## ONLINE COMMENT ON PLANNING APPLICATION 23/11160

Location SITE OF ARNEWOOD COPSE AND  
CARFORD, FARMERS WALK, EVERTON,  
HORDLE SO41 0JZ

Objection received from Dr David Miller  
1 Shepherds Way  
Everton  
SO41 0DB

**1** Ground Floor Plan - Dwelling C

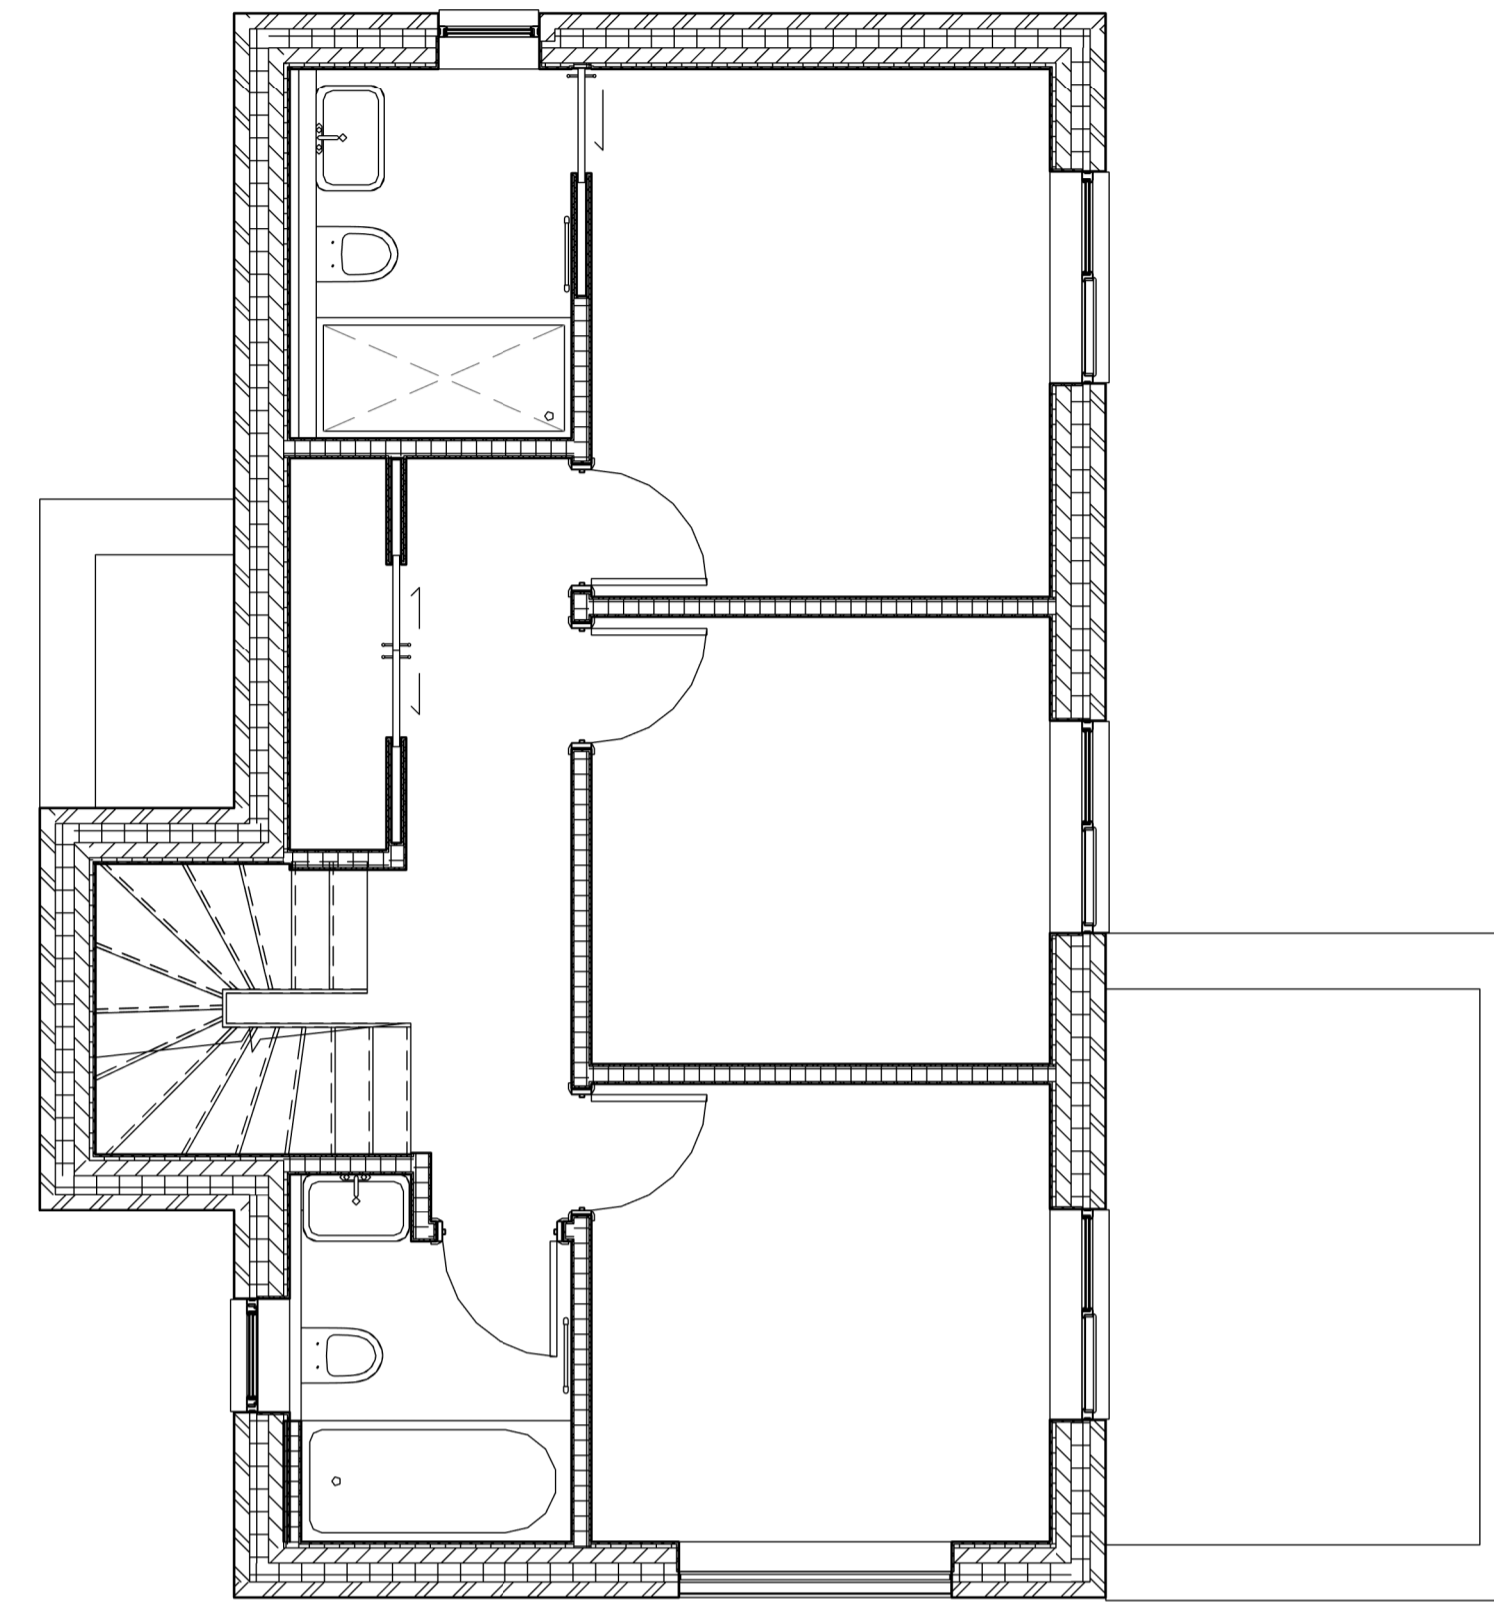
The revised proposal to move the location of the bin and bike store for Units A and B, amalgamating them to the front of the project, seems straightforward and we have no objection. However, this revision serves to reinforce our earlier criticism that no equivalent provision has yet been made for Unit C. We have previously objected to any suggestion by the developer that refuse sacks (or, as seems likely in future, refuse bins) could be taken onto Shepherds Way. The defining point remains that the verge here is private land owned by Shepherds Way Residents Ltd. As previously explained, the owners of the Arnewood plot have no right of access onto Shepherds Way across our property.

**3** Second Floor Plan - Dwelling C

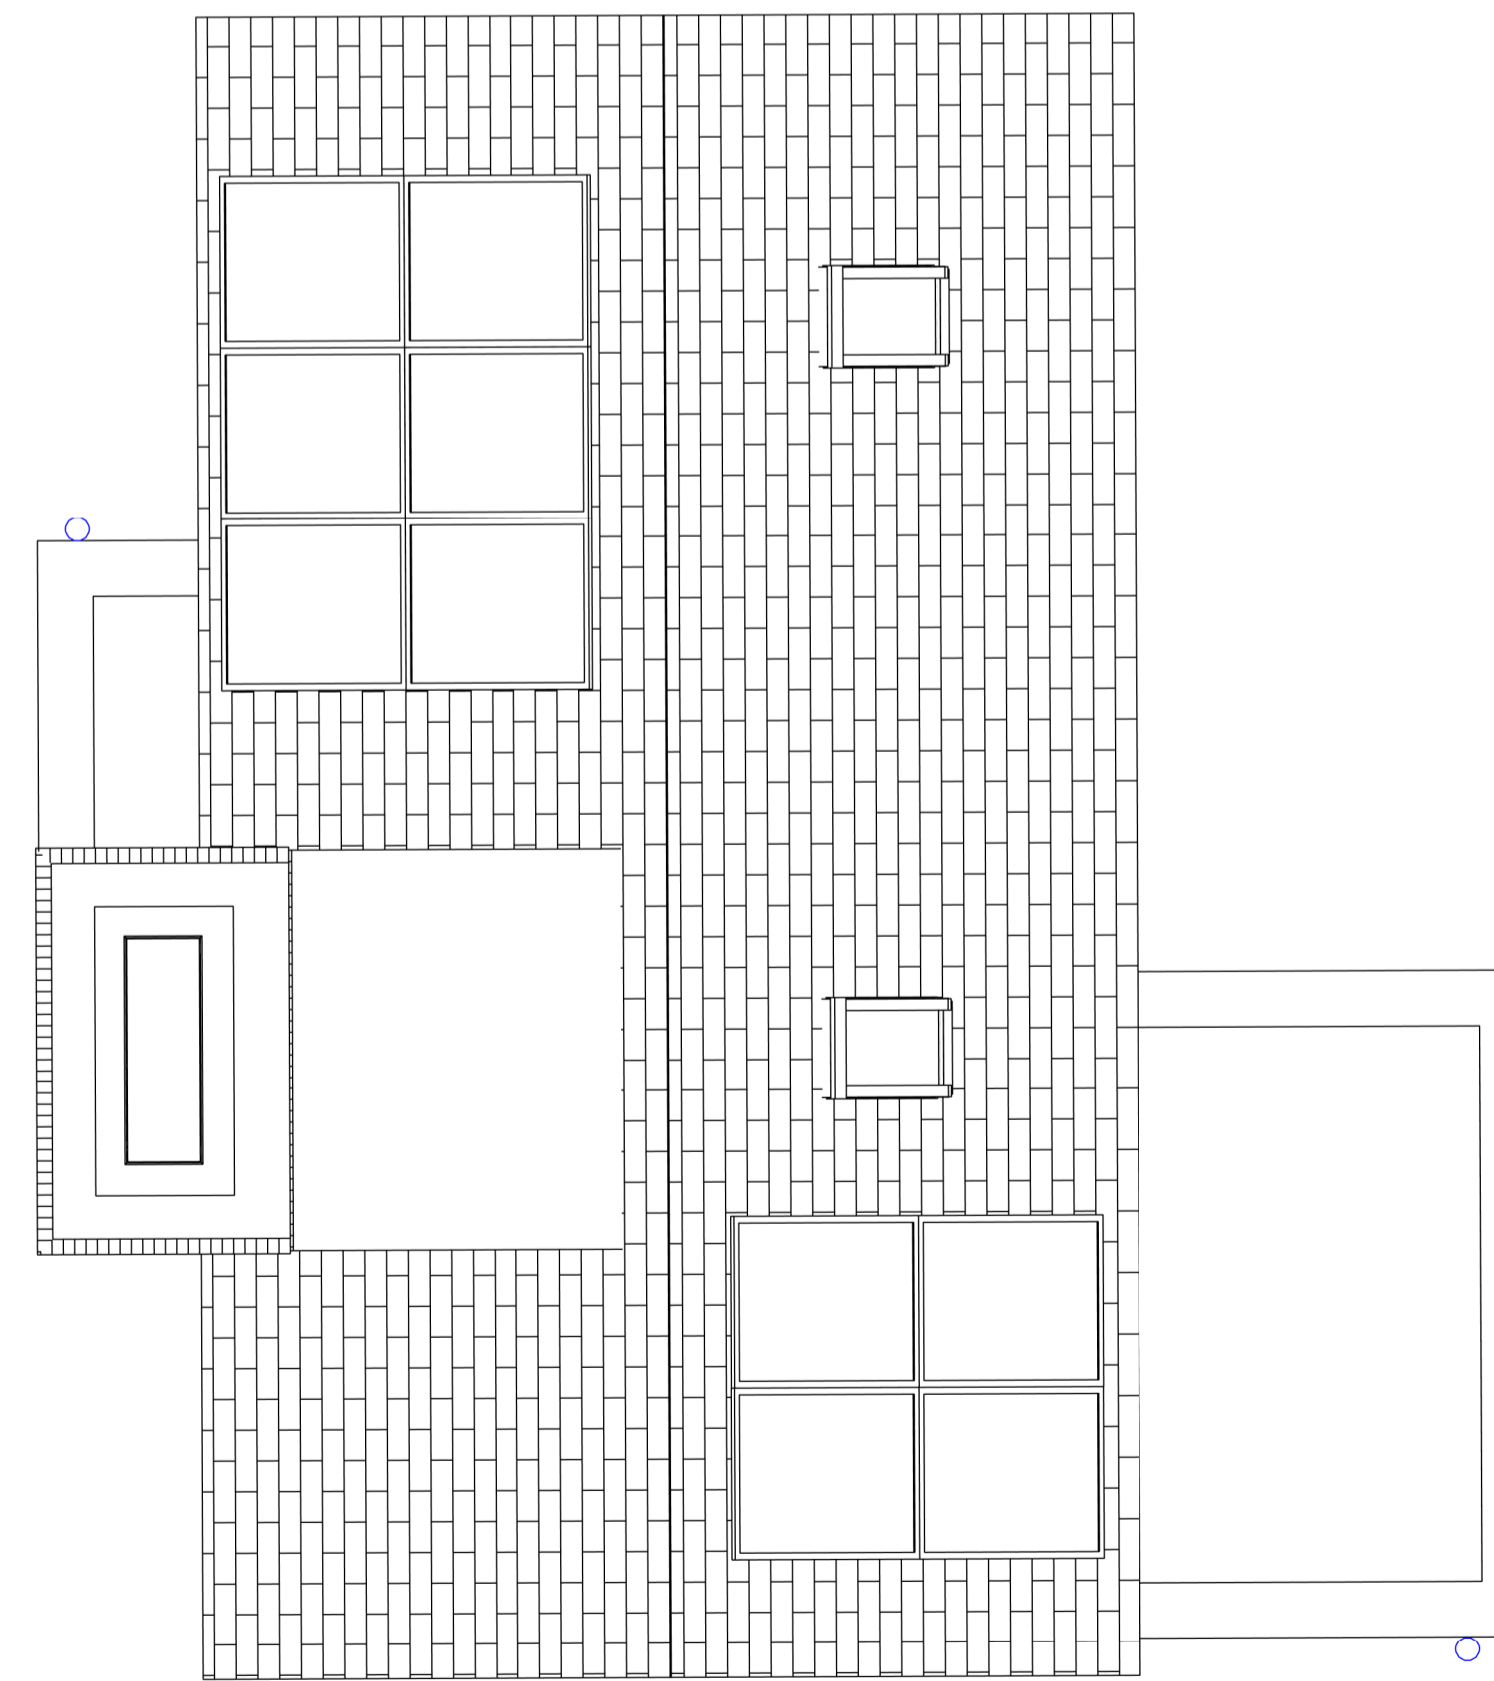
Otherwise, the proposed extension into the roof space of Unit C looks satisfactory since the adjacent properties in Shepherds Way will not be overlooked from there: the revised plan ensures that.
